My ref:
Your ref: TR010018
Date: 28 September 2015
Contact:
Direct dial: 01223 715471
E Mail: andrew.munro@cambridgeshire.gov.uk

**A14 Cambridgeshire to Huntingdon Examination
Issue Specific Hearings – Post Hearing Documentation**

A14 Project Manager – Cambridgeshire County Council

Drawing title: **TRAFFIC REGULATION MEASURES REGULATION 5(2)(o) CLEARWAYS & WEIGHT LIMITS SHEET 17 OF 36**

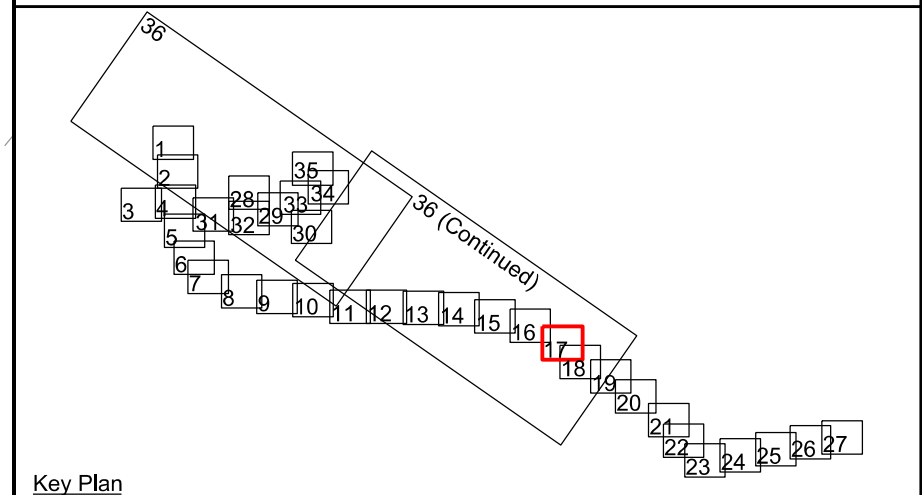
The Council notes that in the CHARM3A model series, the junctions at Views Common, Mill Common, and Swavesey are in the model and provide the restraint that the Examining Authority espoused, but only in combination with the Brampton Road junctions. The Council has not been able to model the effects of retaining the railway viaduct, but it would seem to the Council that providing free flow at this location would inevitably provide additional capacity. In consequence the route would be more attractive to strategic traffic. The Council in any case would be concerned over the combination of at-grade and grade separated junctions with heavier traffic.

Consequently, the Council, until Highways England has been able to provide modelling data with the Swavesey Junction in its proposed form, remains of the opinion that if the viaduct was retained or replaced the existing A14 is likely to form a strategic route from the A1(M) to the M11.
